OXFORDSHIRE COUNTY COUNCIL'S RESPONSE TO CONSULTATION ON THE FOLLOWING DEVELOPMENT PROPOSAL

Application no: 14/02121/OUT-2

Proposal: OUTLINE - Development to provide up to 1,700 residential dwellings (Class C3), a retirement village (Class C2), flexible commercial floorspace (Classes A1, A2, A3, A4, A5, B1 and C1), social and community facilities (Class D1), land to accommodate one energy centre and land to accommodate one new primary school (up to 2FE) (Class D1). Such development to include provision of strategic landscape, provision of new vehicular, cycle and pedestrian access routes, infrastructure and other operations (including demolition of farm buildings on Middleton Stoney Road)

Location: Proposed Himley Village North West Bicester Middleton Stoney Road Bicester Oxfordshire

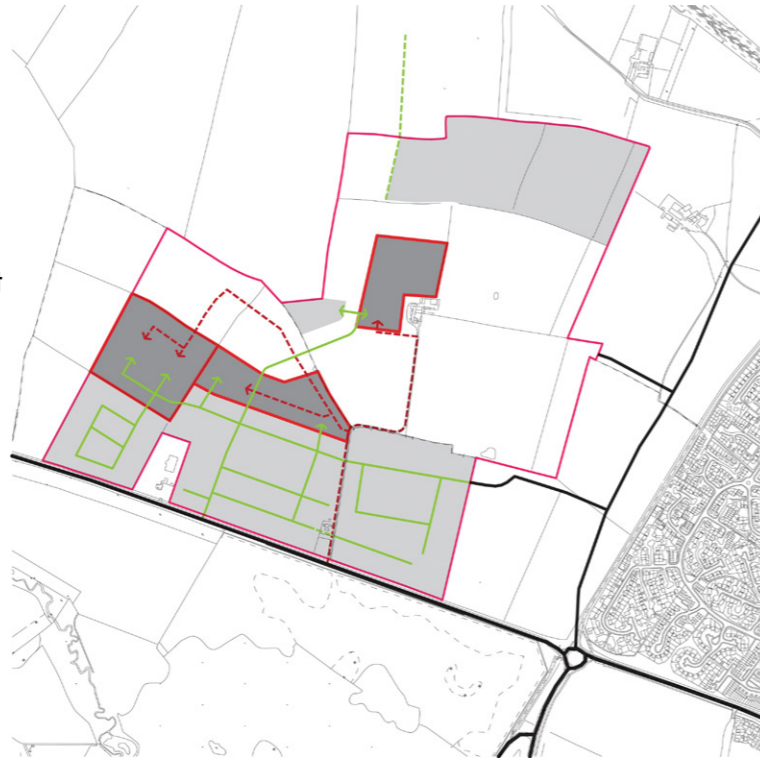
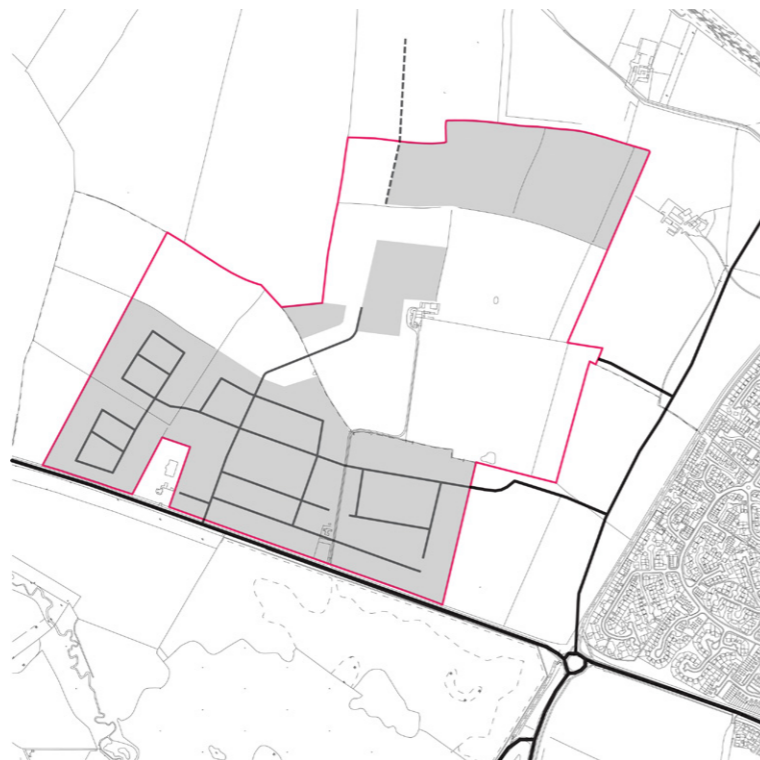
The School location has changed from that demonstrated in the original overall 'ecotown' masterplan and the layout presented at outline and amended outline planning does not comply with the basic School dimension/shape requirements for a primary school site. It would appear guidance may have dropped off previous correspondence.

The site shape and dimensions demonstrated will not be conducive to an economical layout or a best value solution to meet OCC's educational, safeguarding and management requirements.

NB See attached proposal for the re-siting of the school site to nearer its original position and to suit the educational site requirements

- The school site should be approximately rectangular in shape with the main frontage of a school not less than 110m long to enable the school site to be laid out to meet access and safeguarding requirements. The school's site within the amended application does not comply with this requirement.
- The building height parameters plan suggests that the school building will be 4m to 10m high. For any school building this should be amended to - Minimum height will need to be 2.5m – 10m
- Swales appear to be located all around the school site we should discuss the location of crossings when we know the final location of the school site and building to ensure that pupils are not tempted to cross through the potentially muddy swales.

The applicant representatives must engage with Oxfordshire Property & Facilities to define an appropriate school layout that meets the specification in the embedded document 26395 Educational Requirements for Residential Development.

Outline SuDS Parameter Plan

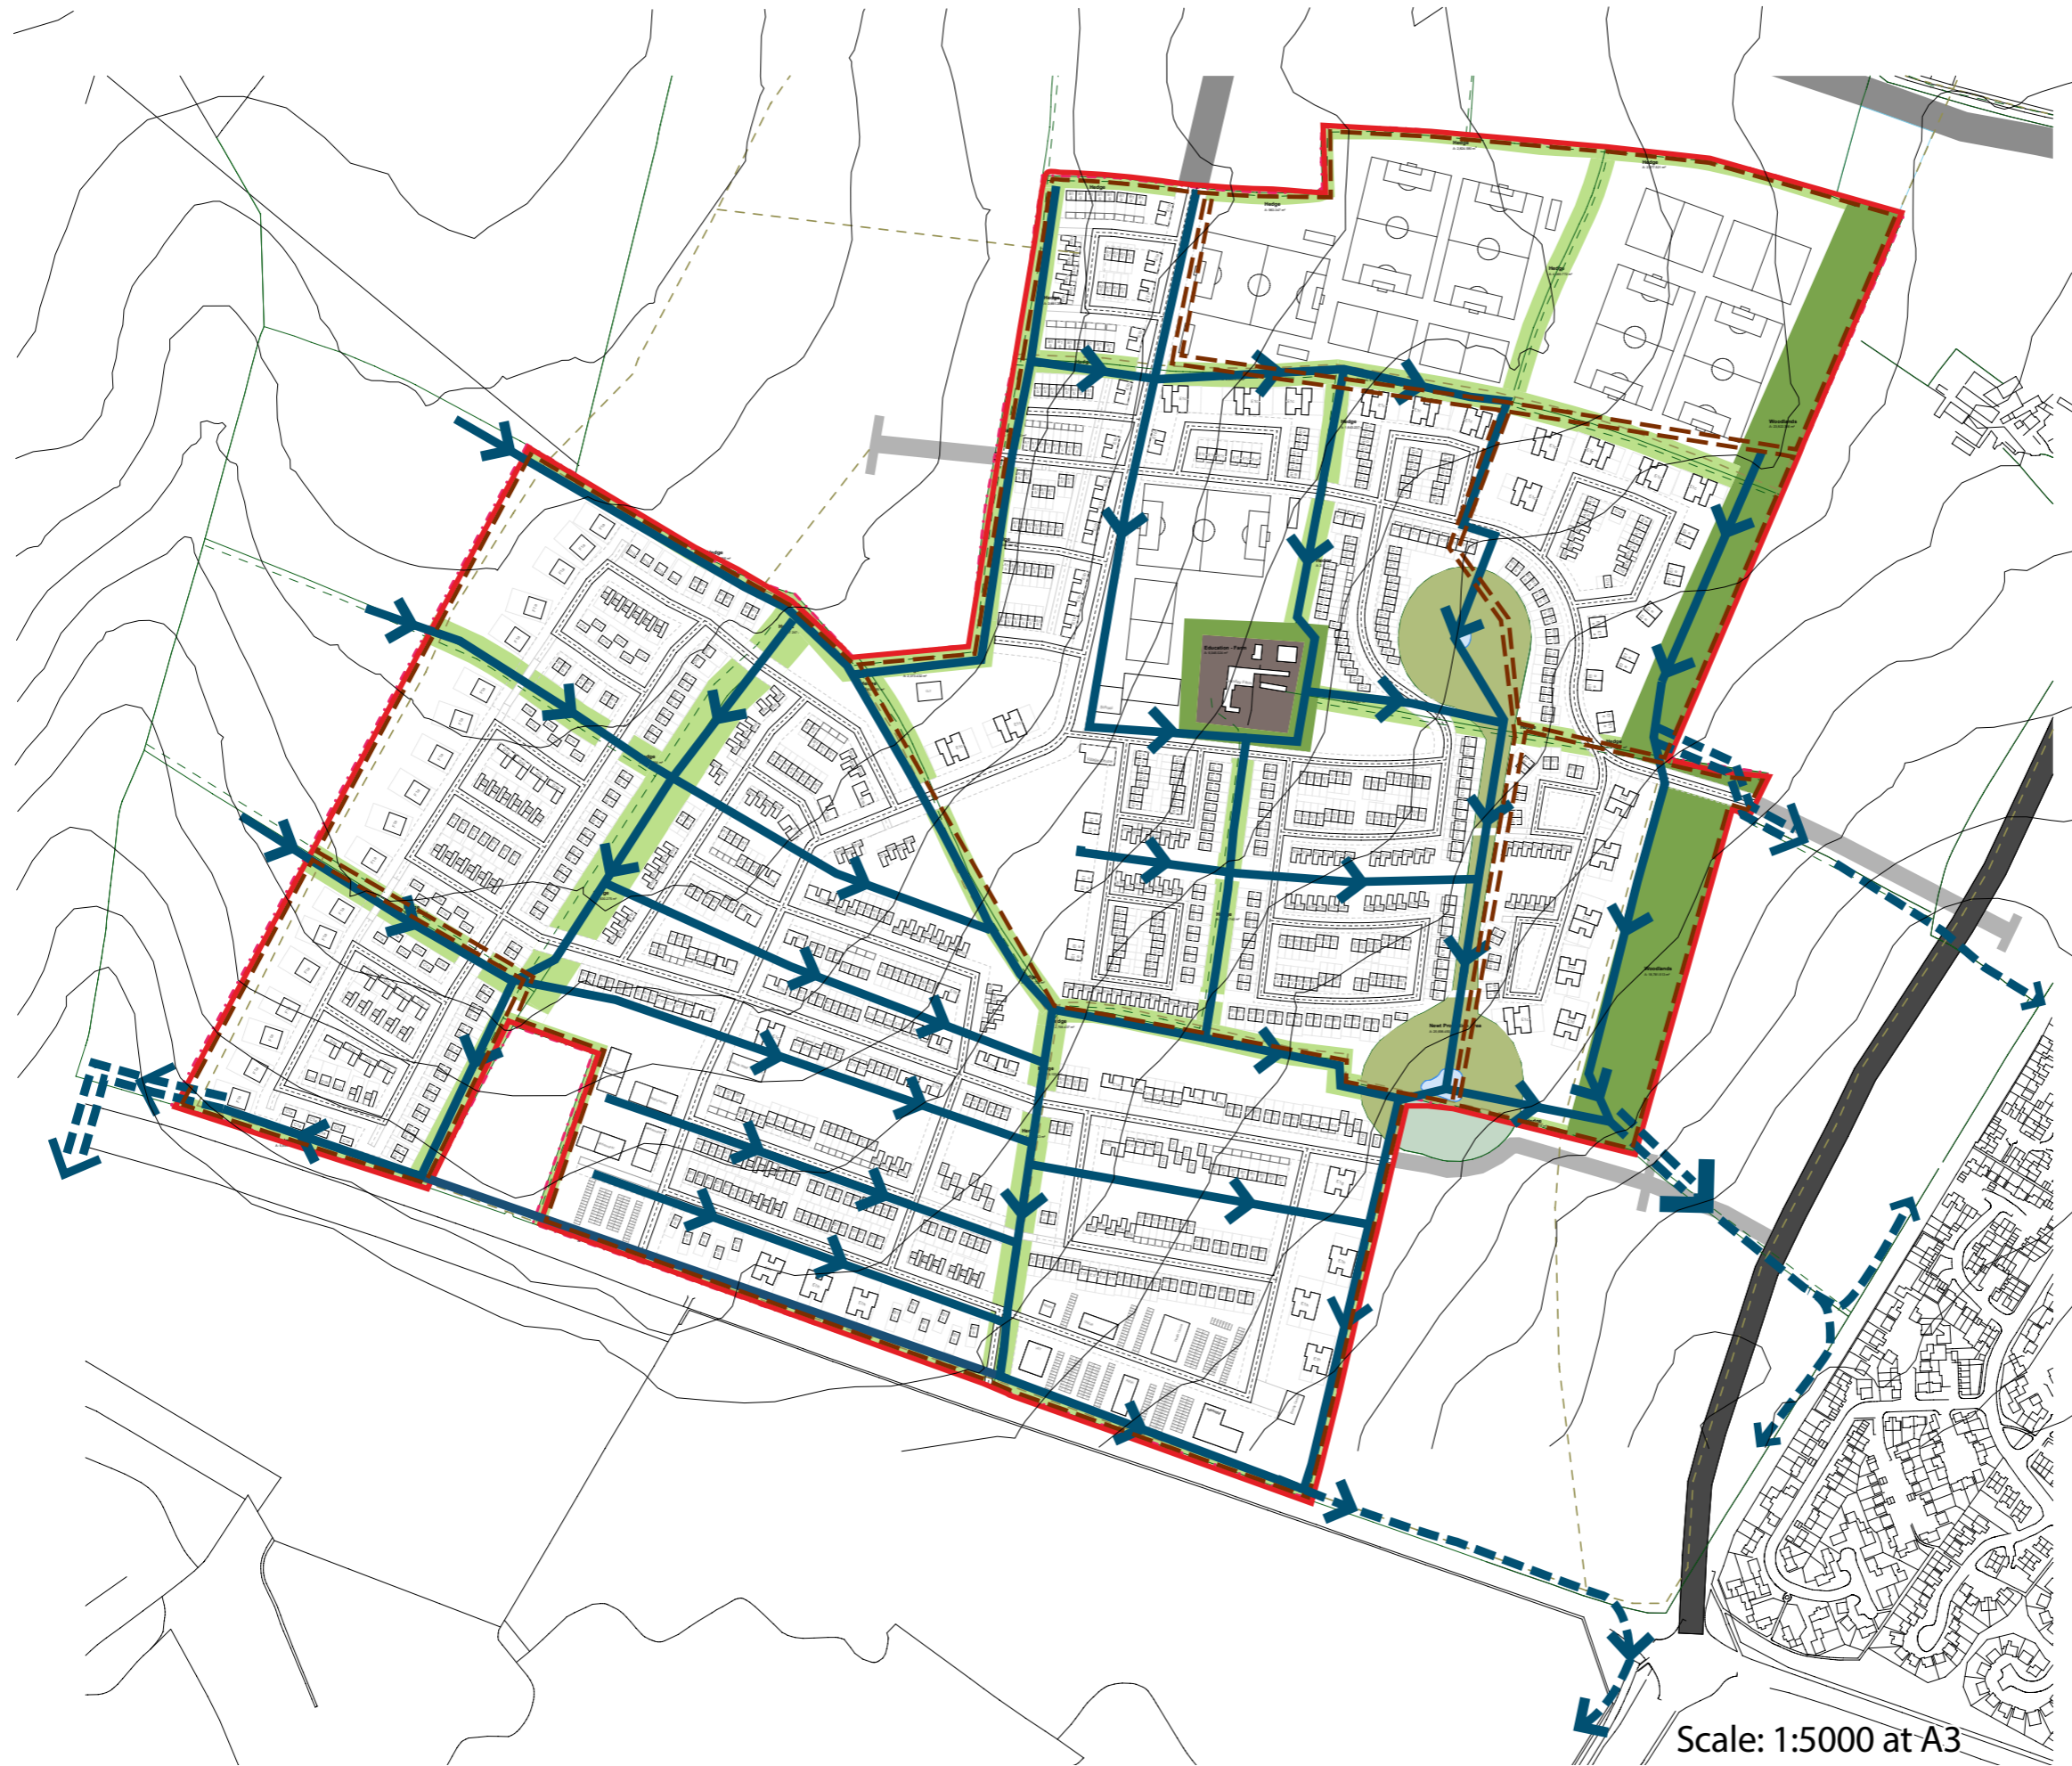
The County Council's drainage team has no objection to the proposed changes to the swale layout.

The only relevant amendment listed in the summary of amendments is with regard to drainage. The county council's drainage team has no objection to the proposed changes to the swale layout.
